Application Ref:	3/2025/0039			 Ribble Valley Borough Council www.ribblevalley.gov.uk
Date Inspected:	20/02/2025	Site Notice:	20/02/2025	
Officer:	MC			
DELEGATED ITEM FILE REPORT:				REFUSAL

Development Description:	Proposed demolition of existing dwelling and erection of new two-storey detached dwelling with rooms in the roofspace. Installation of Air Source Heat Pump and Solar Panels.
Site Address/Location:	Dilworth Cottage, Ward Green Lane, Longridge, PR3 2ZL

DRAWING TITLE
Proposed Elevations

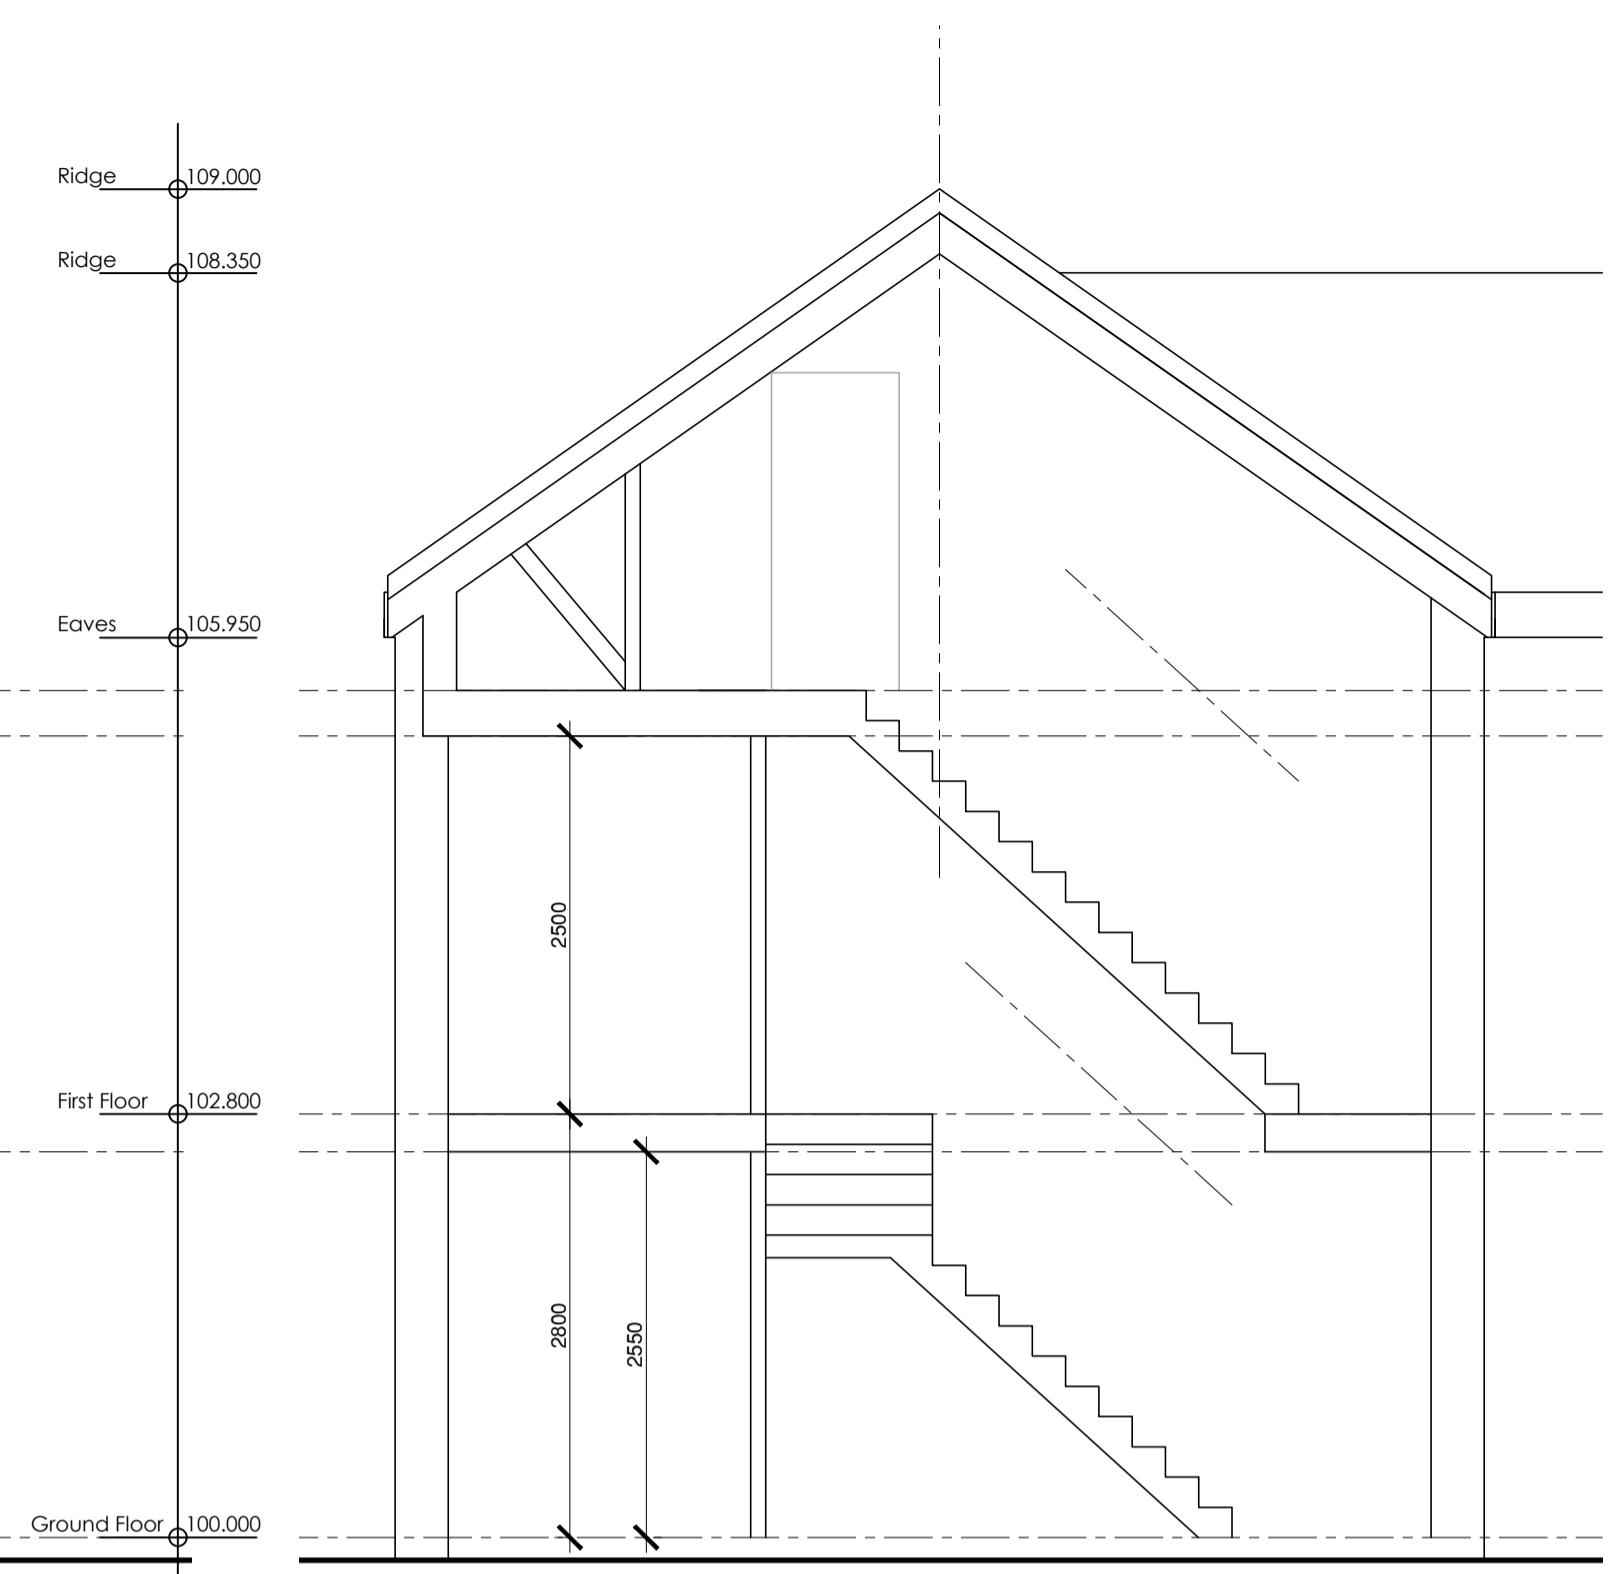
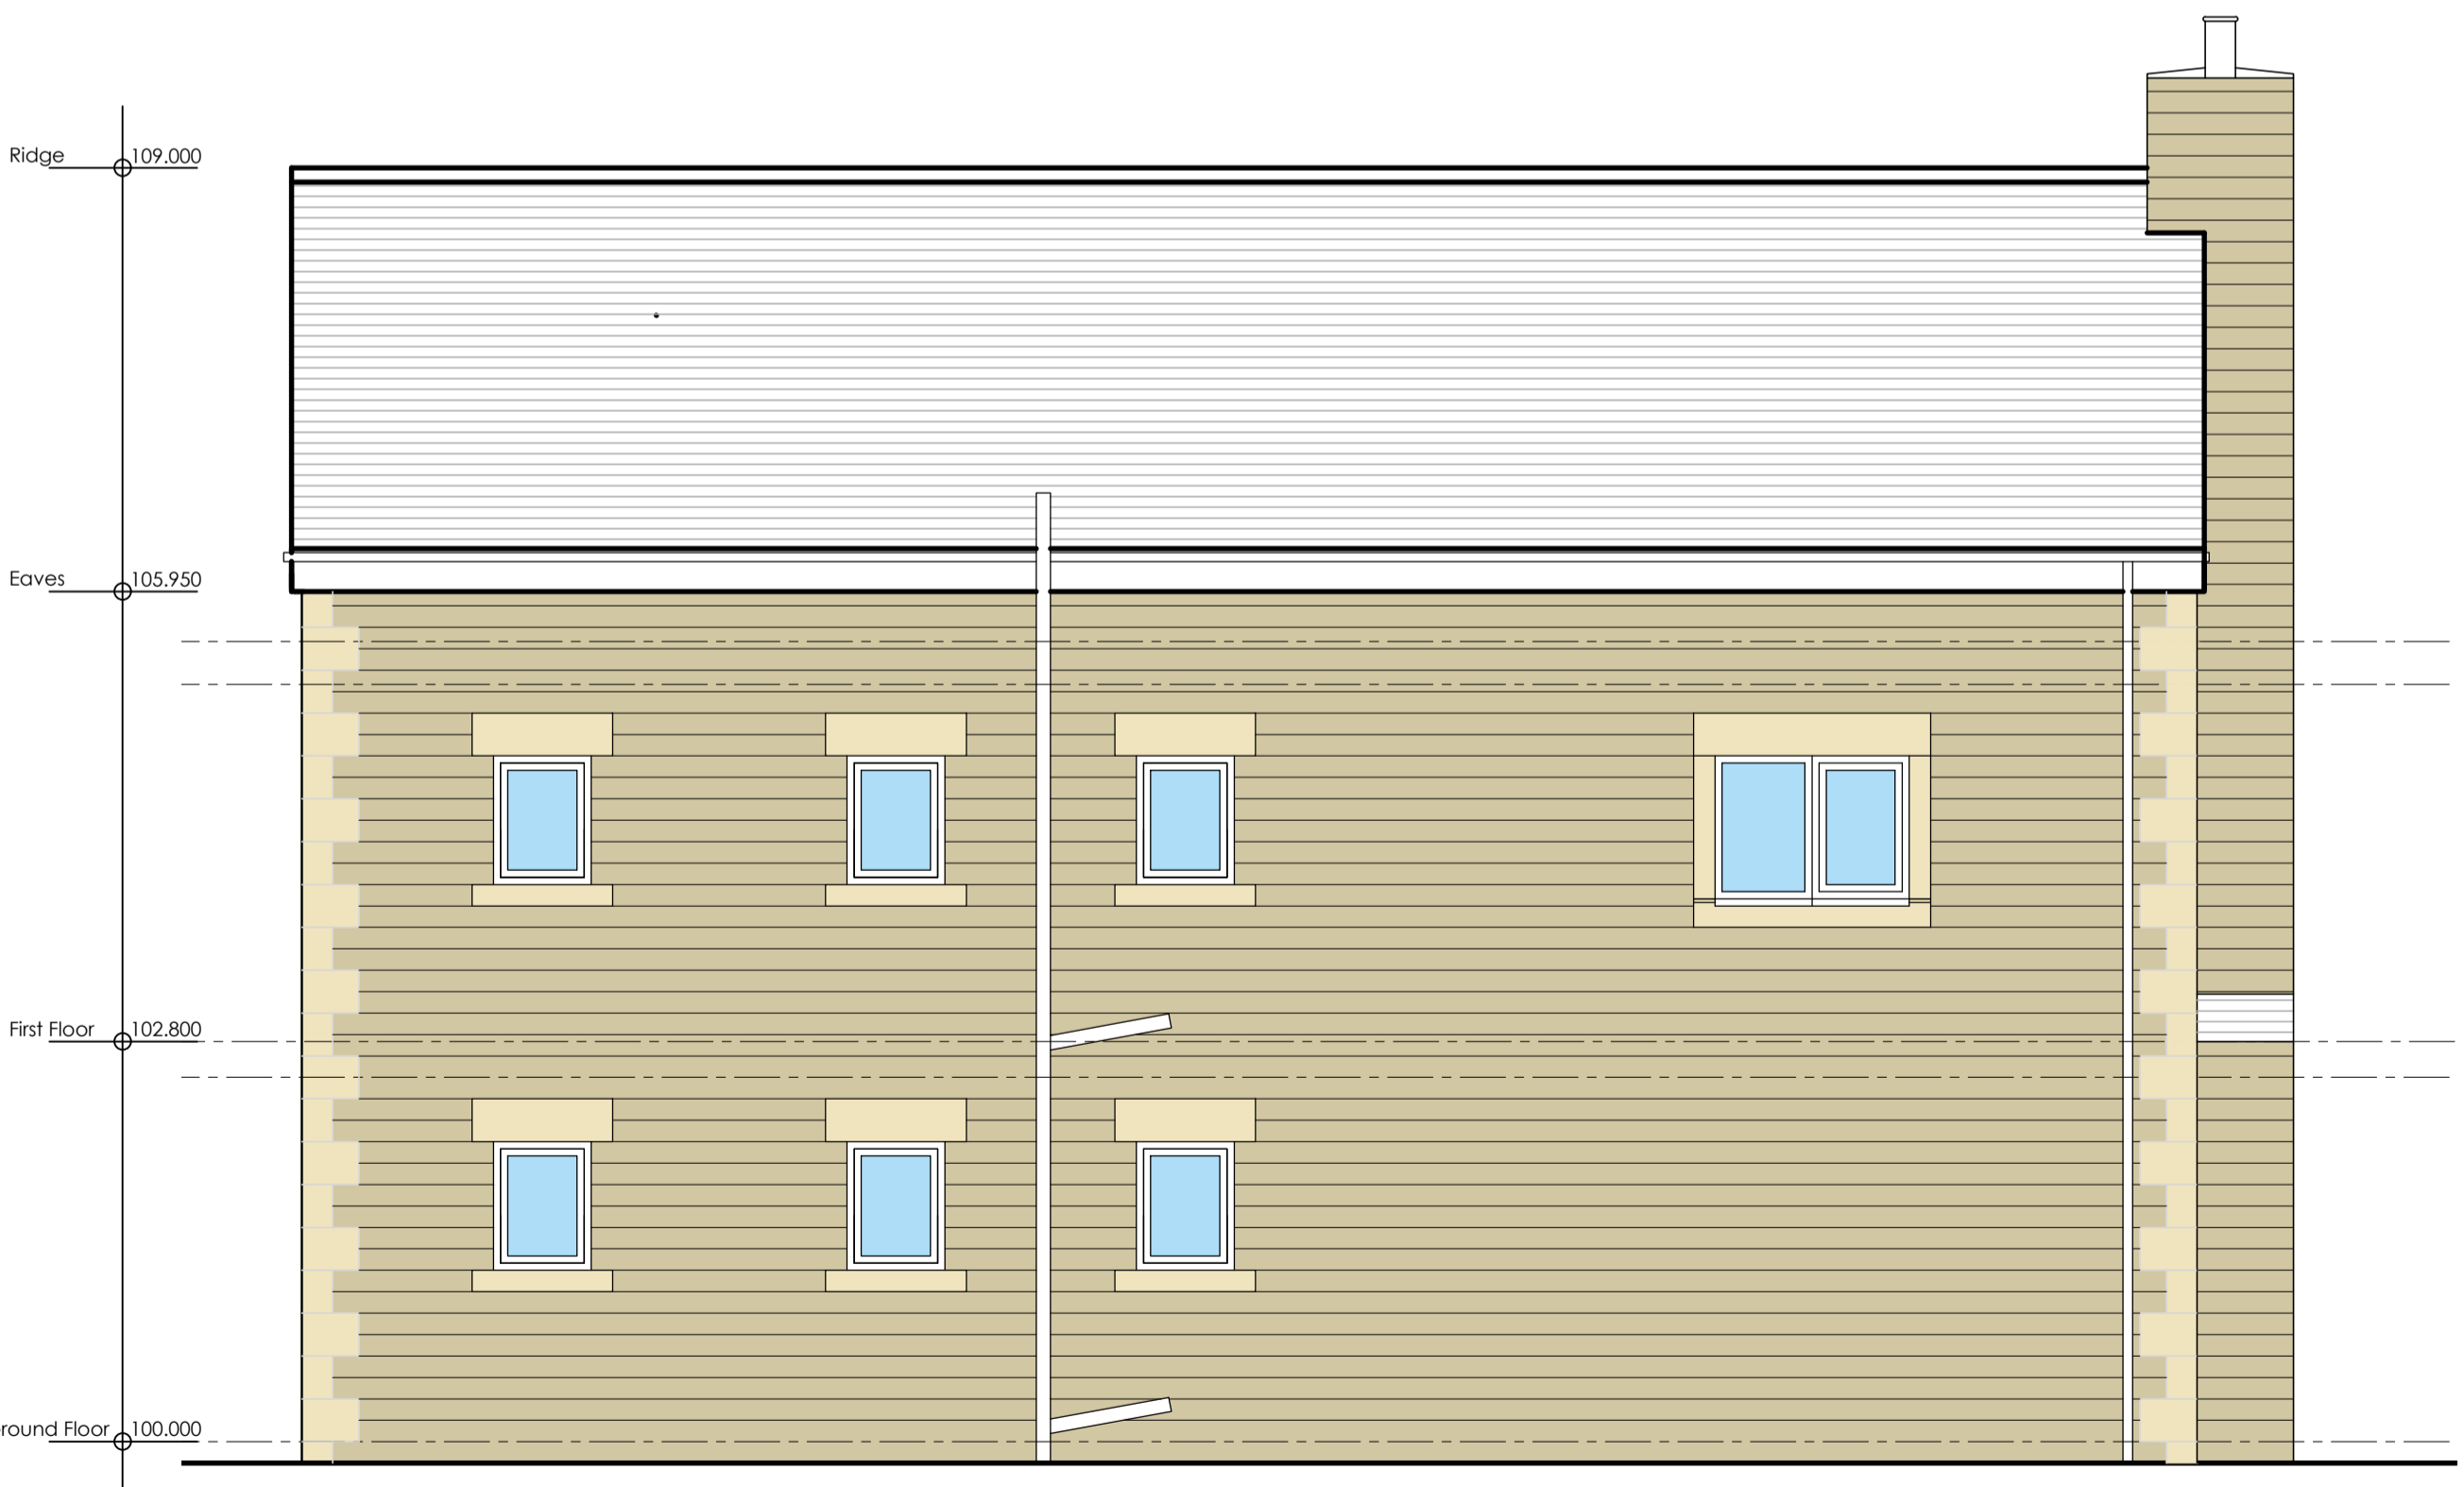
With regards to the proposed dwelling itself, this would be approximately 9.1 metres to the top of the roof ridge and 10.1 metres approximately to the top of the chimney. The eaves height would be approximately 6.4 metres. The proposal would have a two-storey gable roof front projection which would be set down from the main roof ridge by approximately 0.5 metres. This gable projection would include double doors with a Juliet balcony at first floor level to the front elevation. The external materials of construction would include a slate roof, brown uPVC soffits and fascias, brown uPVC windows and doors and to the walls, natural stone with stone quoins. Solar panels are also proposed to the front roof slope and an Air Source Heat Pump adjacent to the eastern flank wall.

Turning to the acceptability of the proposed replacement dwelling, it is noted that this would be much larger in size and scale than the demolished dwelling which is a much smaller, stone-built dwelling that is typical in character of a dwelling in this location. The dwelling would be approximately 2 metres taller than the existing dwelling, with an eaves height increase of approximately 1.5 metres. Whilst the dwelling would now be sited forward of the boundary with Lower Road, it is considered that it would be more prominent when viewed from Ware Green Lane. The dwelling would no longer appear as a traditional stone-built cottage but would have larger and more modern features of a greater size and scale.

For example, the proposal includes a gable roof projection to the front of the dwelling which would add bulk and mass to the building. Whilst this is not considered to be excessive in depth, its height is considered to add to the prominence of the building. In addition, this gable would feature a two-storey bay window which is not considered to be a typical design feature of the surrounding area. The dwelling is considered to be excessive in height, being 2.5 storeys with accommodation in the loft space. The flank walls include windows at the third-floor level which would likely be visible from Ward Green Lane as some of the trees along the boundary are proposed to be removed. The height of the building is considered to be excessive and the presence of third floor windows on the flank wall would add to the dominating appearance of the dwelling within the site.

Overall, the proposed replacement dwelling, by reason of its size, scale, siting and design, is not considered to be in keeping with the character of the landscape, within the Open Countryside when compared to the distinct character of the existing building which contributes positively to the street scene, contrary to Policies DMG1 and DMG2 or the Ribble Valley Core Strategy and Policy LNPD3 of the adopted Longridge Neighbourhood Development Plan.

Tree Protection Plan (TPP)

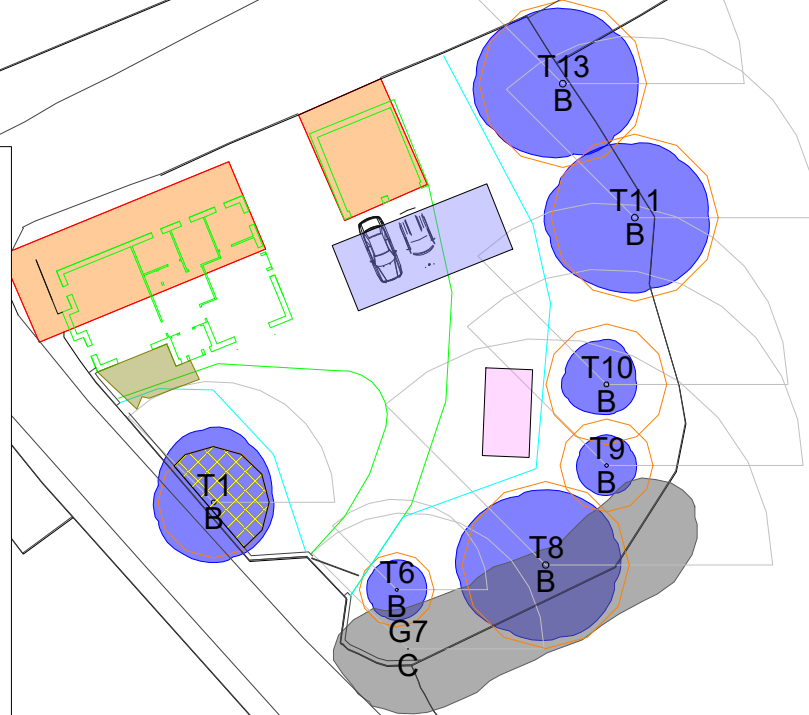
RVBC Countryside Officer:	<p>The Countryside Officer notes that two further emergence surveys are required to be undertaken between May – September.</p> <p>They also recommend a tree protection condition in accordance with BS 5837 Protection of Trees in Relation to Demolition, Design and Construction for category B trees identified on the submitted tree protection plan dated 6th of Jan 2025 be added to any grant of permission.</p>

With regards to landscaping, the proposal would involve the removal of a number of Category ‘C’ trees within the site and would retain eight individual Category ‘B’ trees. The Countryside Officer has provided comments on the scheme and considers that a tree protection condition should be added to any grant of permission to ensure the trees are protected in accordance with BS 5837 Protection of Trees in Relation to Demolition, Design and Construction.
